REPORT UPDATE

Application No: BE/23/14/PL

Location: Adjacent Warehouse site to McDonalds Oldlands Way, Bersted

Description: Change of use from Class B8 (Storage or Distribution) to Class A1 (Shops) including partial demolition

Site Plan as Proposed

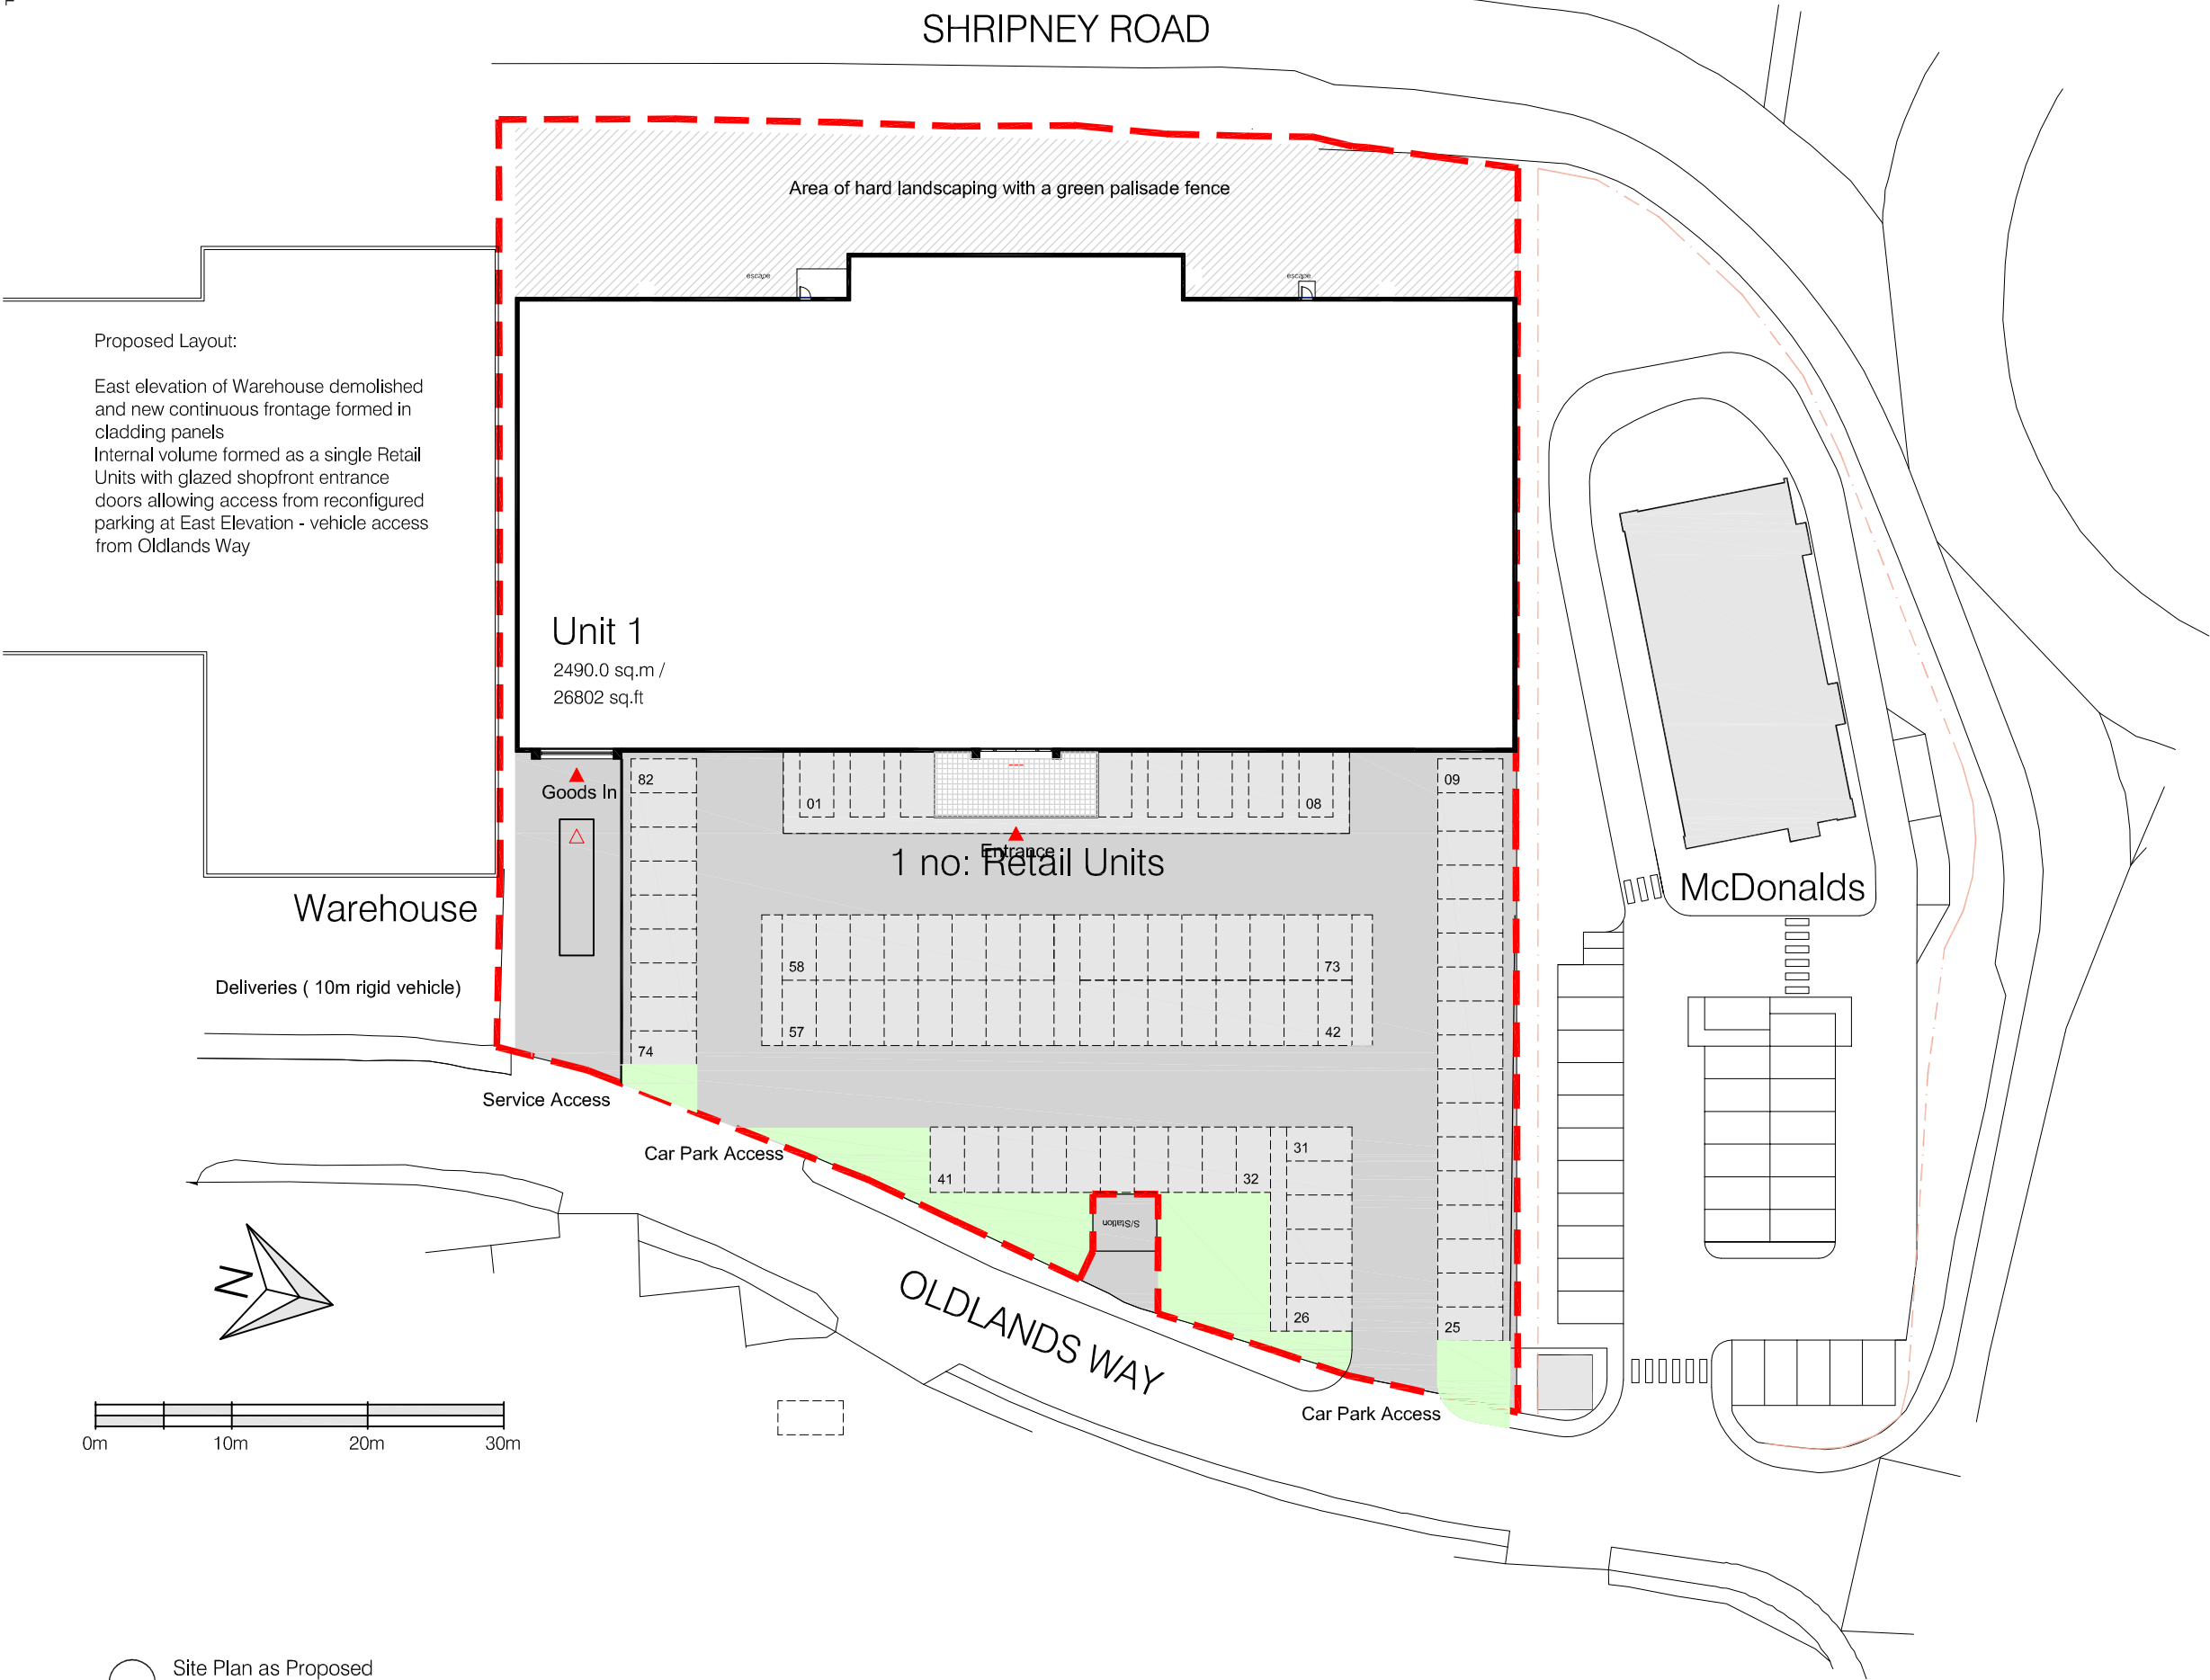
Firstly, with regard to the WSCC Highways objection, the applicant has submitted a Draft Travel Plan and also an amended site plan, the latter which identifies pedestrian routes, cycle parking spaces, staff parking spaces and disabled parking spaces. The applicant has also confirmed to WSCC Highways that food retail is not part of the proposal. As a result, WSCC Highways have stated that parts (a) and (c) of the refusal reason no longer apply. However, WSCC Highways still require the submission of a Stage 1 Road Safety Audit and Designer Response. They have stated that this cannot be made the subject of a planning condition. Therefore part (b) of the refusal reason must remain.
